WEST SUSSEX COUNTY COUNCIL CONSULTATION

TO:	Arun District Council FAO: Anita Gardner
FROM:	WSCC - Highways Authority
DATE:	7 July 2021
LOCATION:	4 Beechlands Close and land east of 18 Montpelier Road East Preston BN16 1JZ
SUBJECT:	EP/69/21/PL 1 No. 3-bed bungalow (resubmission following EP/10/21/PL). This site is in CIL Zone 4 & is CIL Liable as new dwelling.
DATE OF SITE VISIT:	n/a
RECOMMENDATION:	More Information
S106 CONTRIBUTION TOTAL:	n/a

SITE PLAN

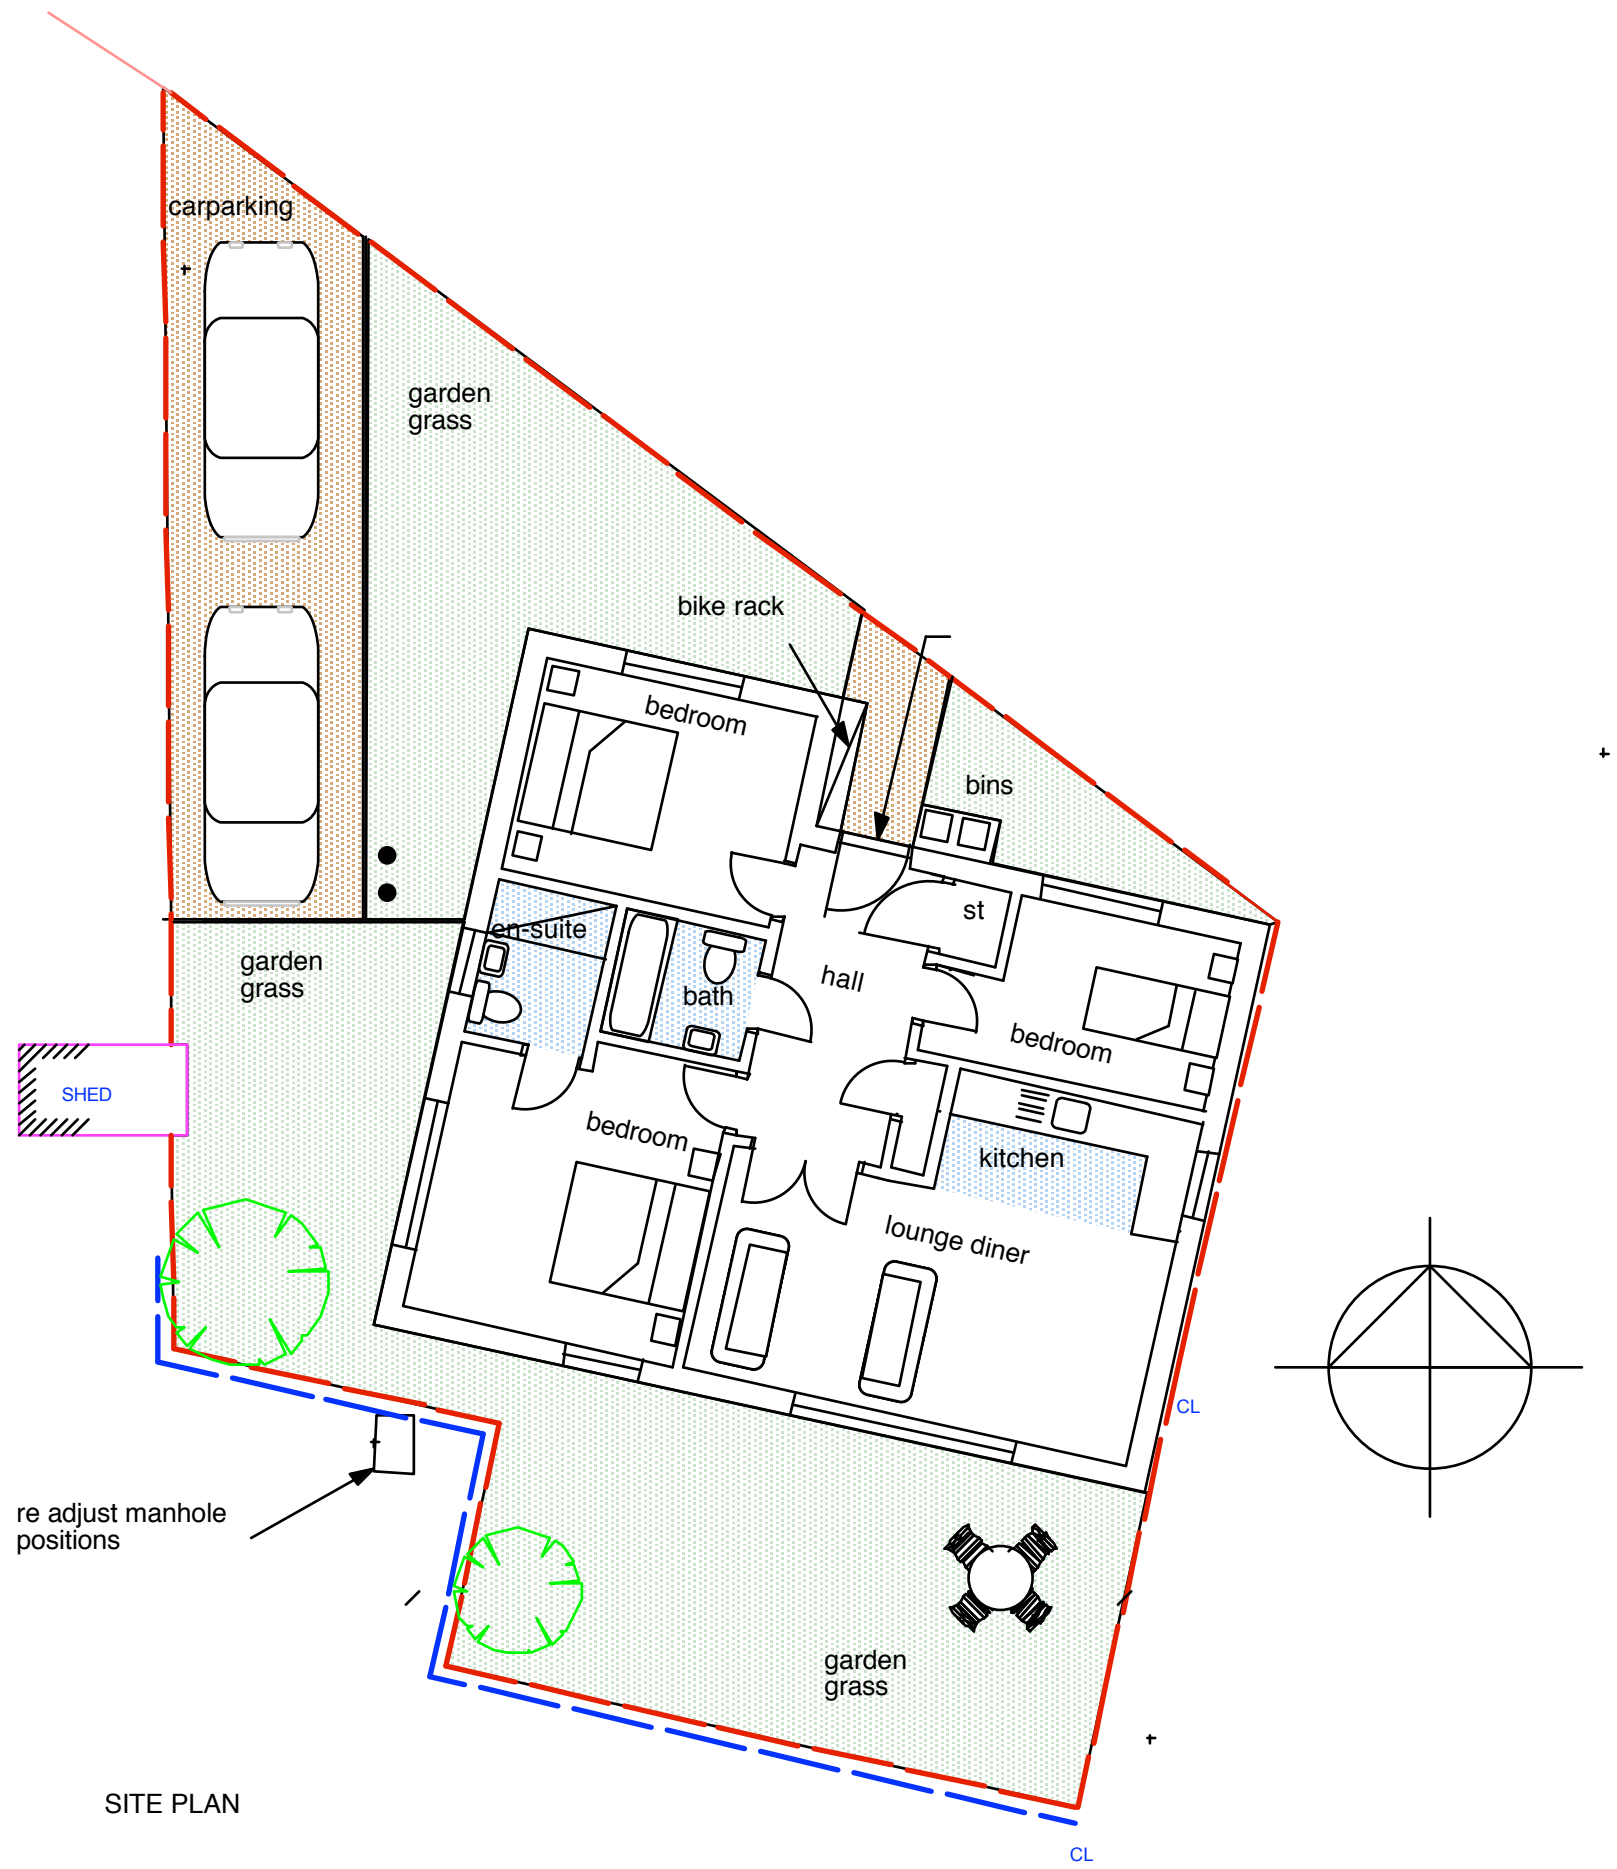
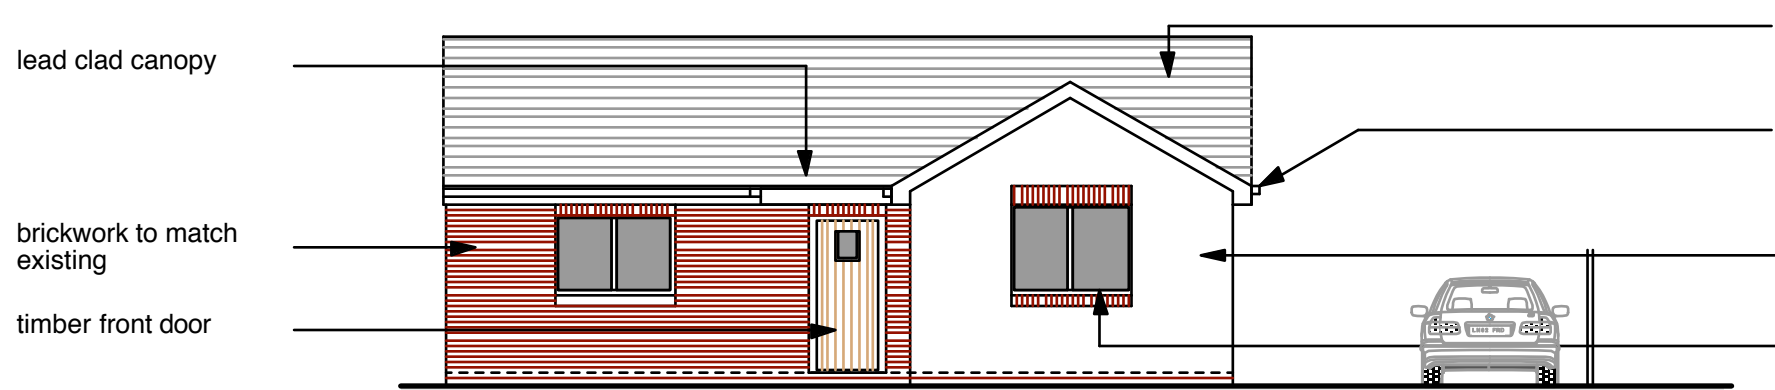
1. Access

1. The LHA requests the applicant provides the access details for the proposal.
2. The LHA recommends the applicant makes sure there parking provisions meet Arun's parking demand calculator.
